Capstone Student Housing

From: Biazar, Shahab
Sent: Monday, November 18, 2013 10:40 AM
To: 'Jeff Wooten'
Subject: RE: Capstone - Revised Zone 2 Grading Plan
Attachments: ZONE 2 WALL MARKUP.PDF

Project Title: Capstone Student Housing - Zone 2 Area Building Permits City Drainage #: M15D026
DRB#: 1009090 EPC#: 11EPC-40091/40092/40093 Work Order#: _____
Legal Description: Parcel 1A block 3 of Lots 1A, 2B, in Block 3, Parcels 1A1, 1A2, 1B1 in Block 4, Parcels 2A, 2B, 2C, & 2D of Sunport CONT
City Address: _____

**Re: Revised Capstone Drainage Management Plan
Zone 2 Grading Plan
Engineer's Stamp Date 11-20-2013 (M-15/D026)**

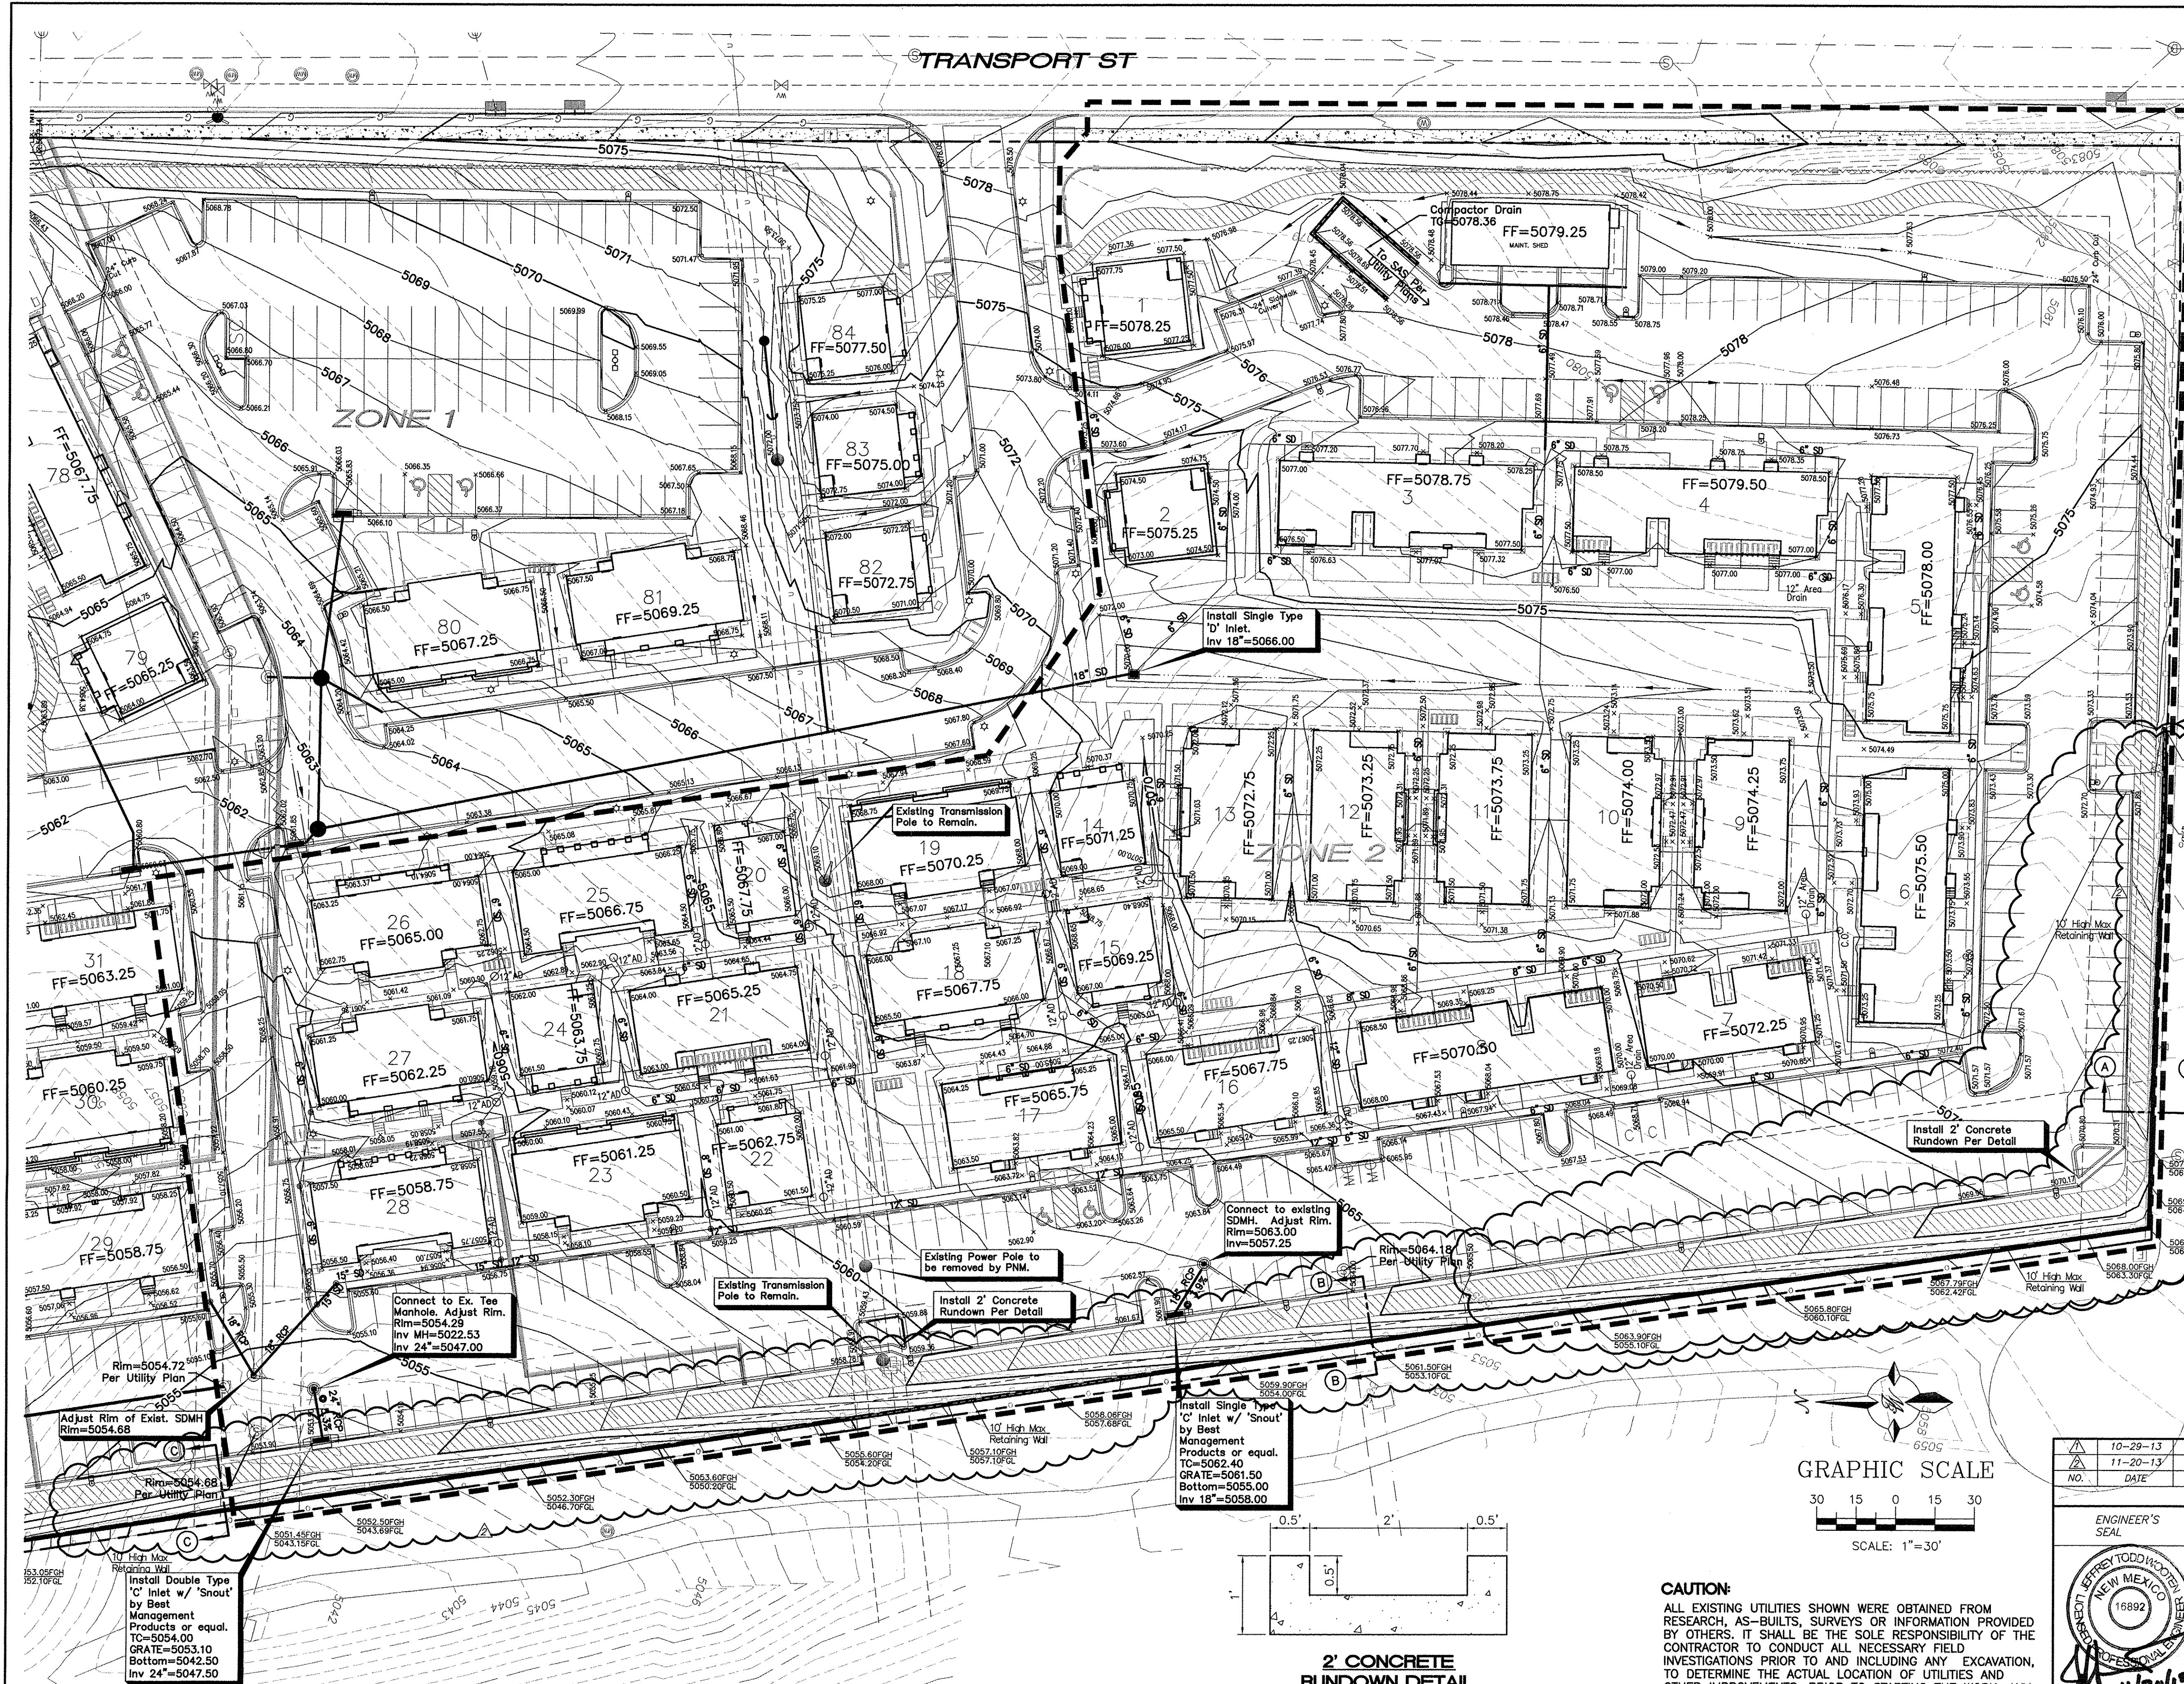
How is the wall being constructed where by the drop inlet? Will there be any conflict with tension mats? Are there any other conflicts with utilities?

Can the Wall
Be Moved to R
To give More Distance
to Slope

*I talked w/ Jeff & he will come up w/
an alternative Plan Shahab 11/18/13*

- We may have to remove the inlet as shown on the plan. The reason for having this previously was because of the cast in place wall and minimizing and drainage behind the wall. In the case of the Keystone wall, drainage should be ok to flow to the wall and over if necessary. There will not be any concentrated flows in this case and the area draining to the wall is only a 13' wide landscape area. The multi-use trail is constructed of crusher fines and is pervious.

- I am not aware of any conflicts with the tension mats except for the aforementioned drop inlet. Removing the inlet as suggested would solve this issue. Let me know your thoughts so I can adjust the plan and resubmit.

- I am not aware of any other conflicts with utilities except where the existing public sanitary sewer and storm drain lines will cross under the wall. These existing lines are very deep and will not be in direct conflict with the geo-grid.

Pricing just came back in on this wall and if I go by to the Client again telling them I need to raise the wall they are going to kill us....literally. Raising the wall even by 1' would raise the price by about \$50,000. I tried your office line and couldn't get through...can you call me when you get a chance to discuss?
